From: [Pat Nicholson](#)
To: [Rachael Stevie \(CD\)](#)
Subject: RE: BL-20-00008 Ogg - Notice of Application
Date: Thursday, March 12, 2020 8:22:22 AM
Attachments: [image001.png](#)

From: Rachael Stevie (CD) <rachael.stevie.cd@co.kittitas.wa.us>
Sent: Wednesday, March 11, 2020 10:30 AM
To: Pat Nicholson <pat.nicholson@co.kittitas.wa.us>; Candie Leader <candie.leader@co.kittitas.wa.us>; Holly Erdman <Holly.erdman@co.kittitas.wa.us>; Jesse Cox <jesse.cox@co.kittitas.wa.us>
Cc: Lindsey Ozbolt <lindsey.ozbolt@co.kittitas.wa.us>
Subject: BL-20-00008 Ogg - Notice of Application

Please review the following Boundary Line Adjustment application submitted David and Kathleen Ogg (BL-20-00008). Any comments need to be submitted by 5pm on March 26, 2020. Please let me know if there are any questions.

BOUNDARY LINE ADJUSTMENT BL-20-00008

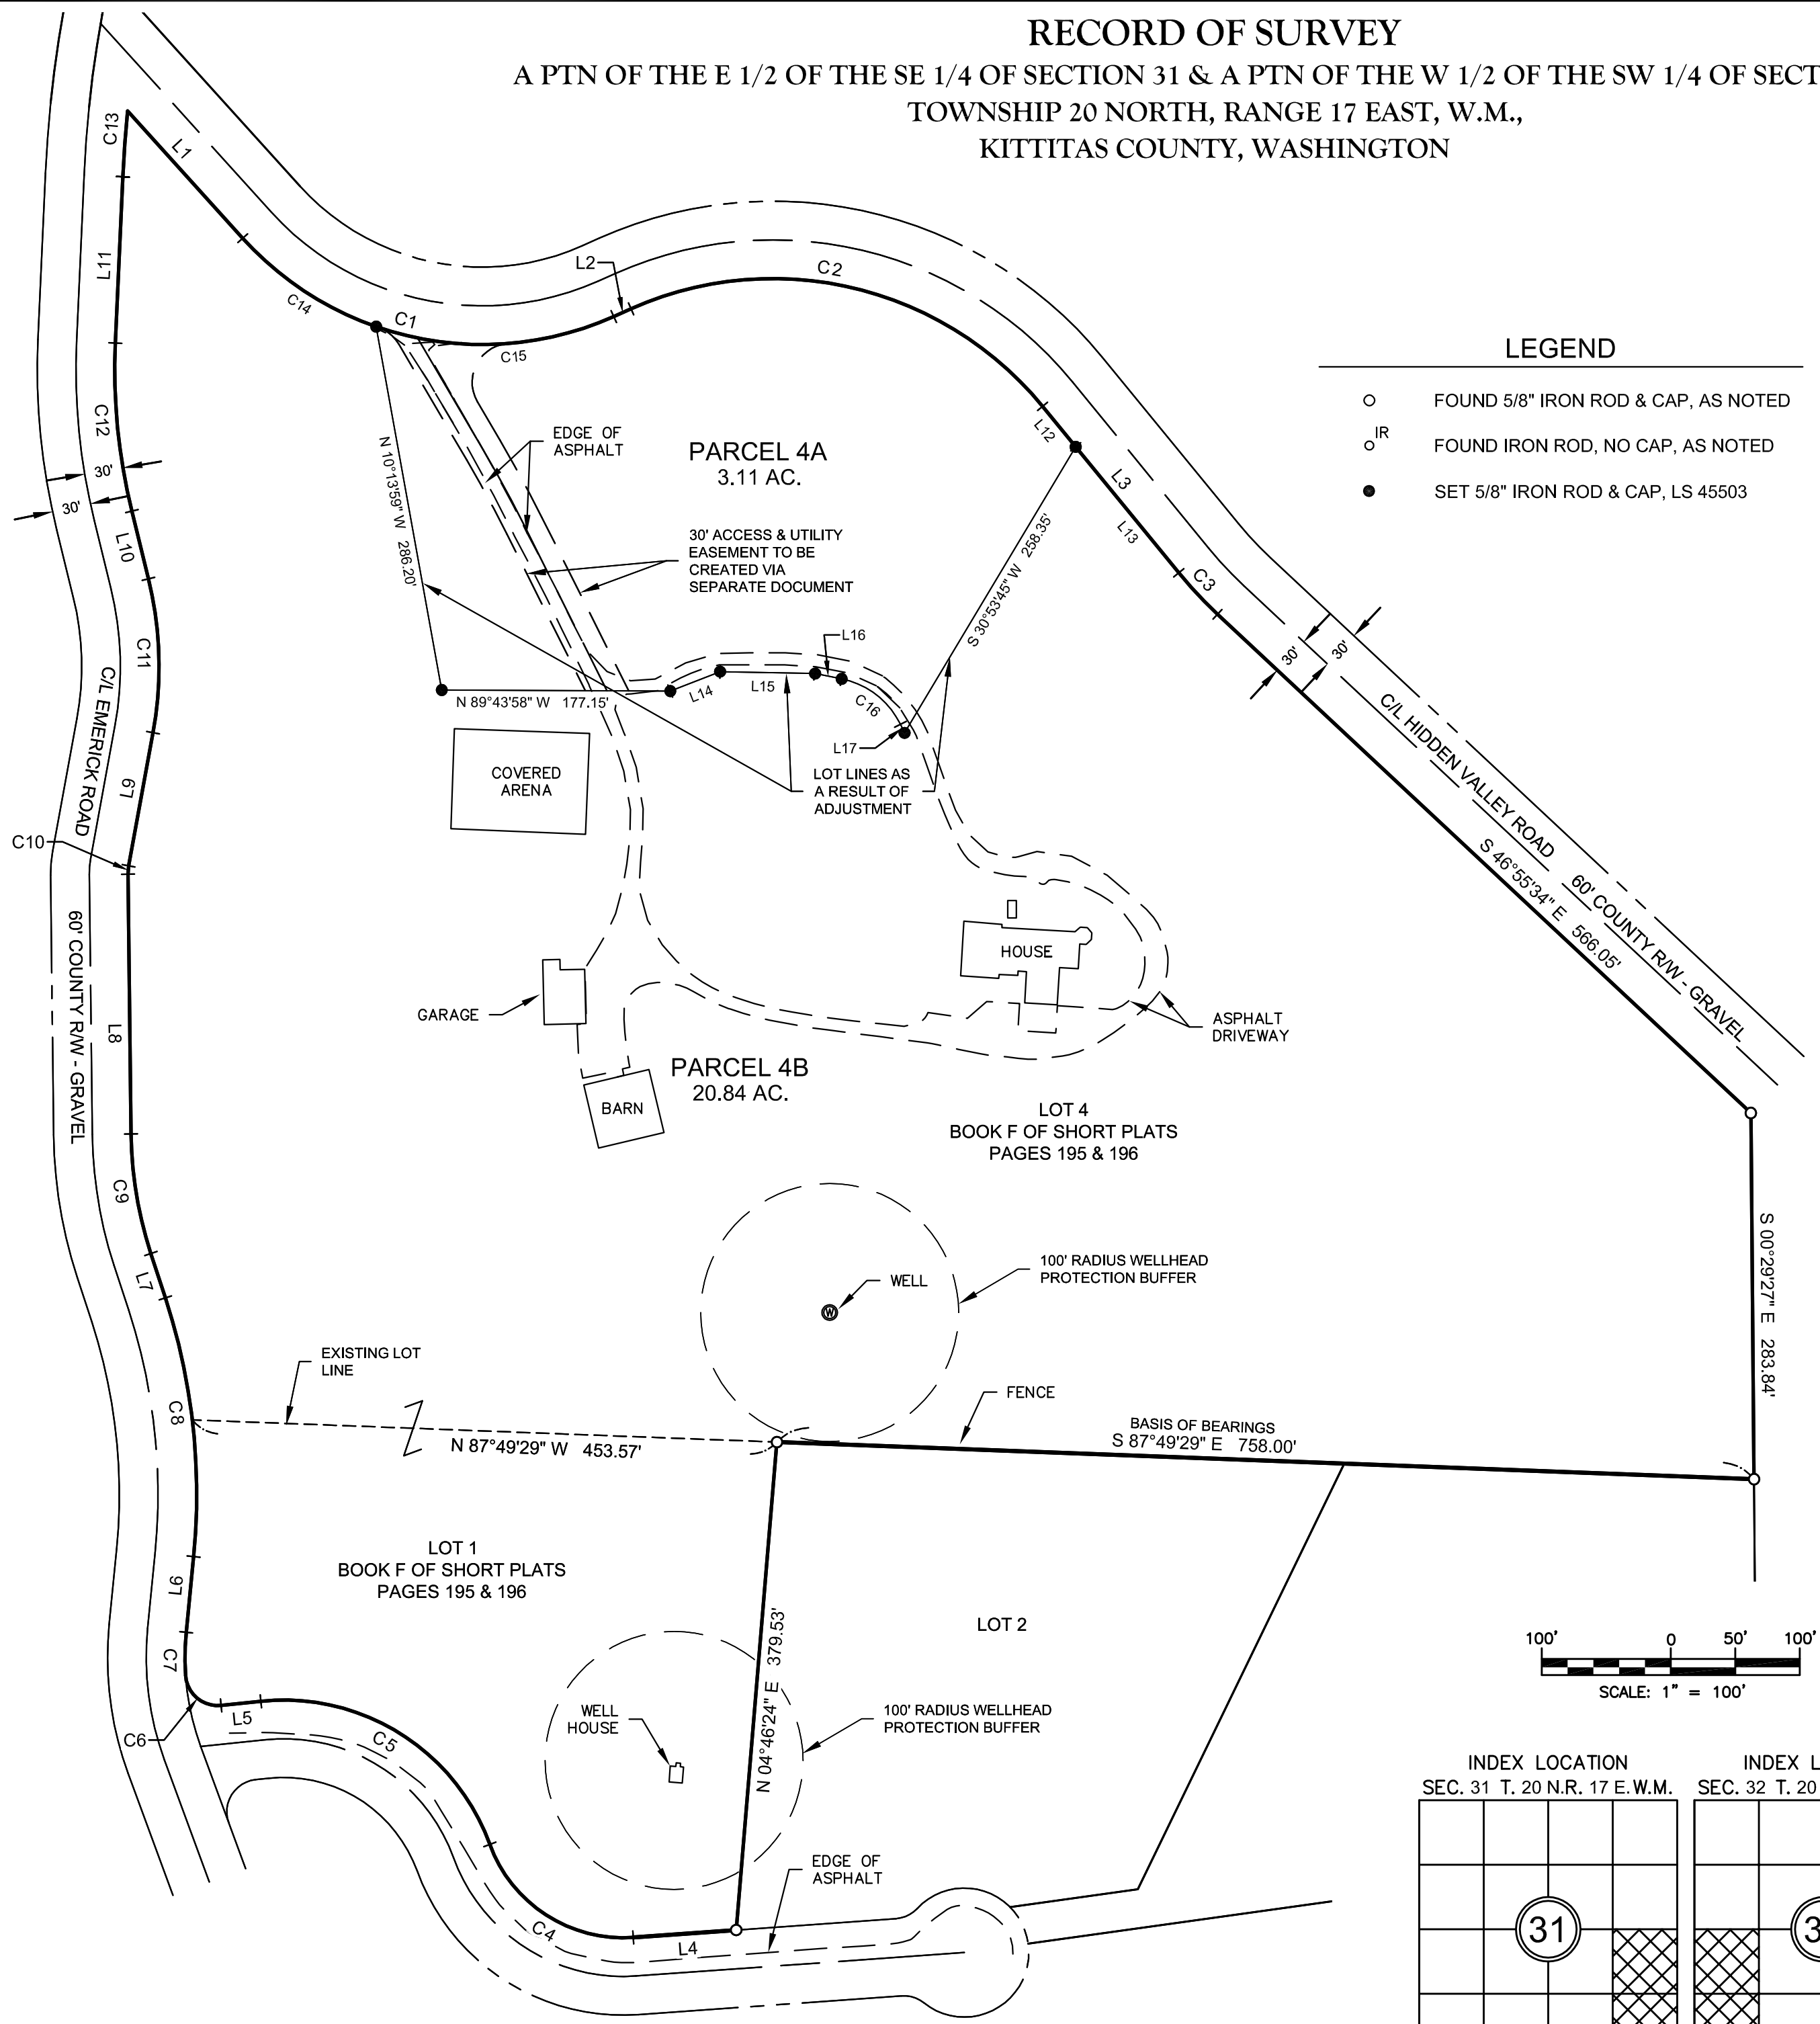
The access will need to meet current IFC and PW standards for 20 foot width, 75,000 lb capacity, and grade with an approved turn around.
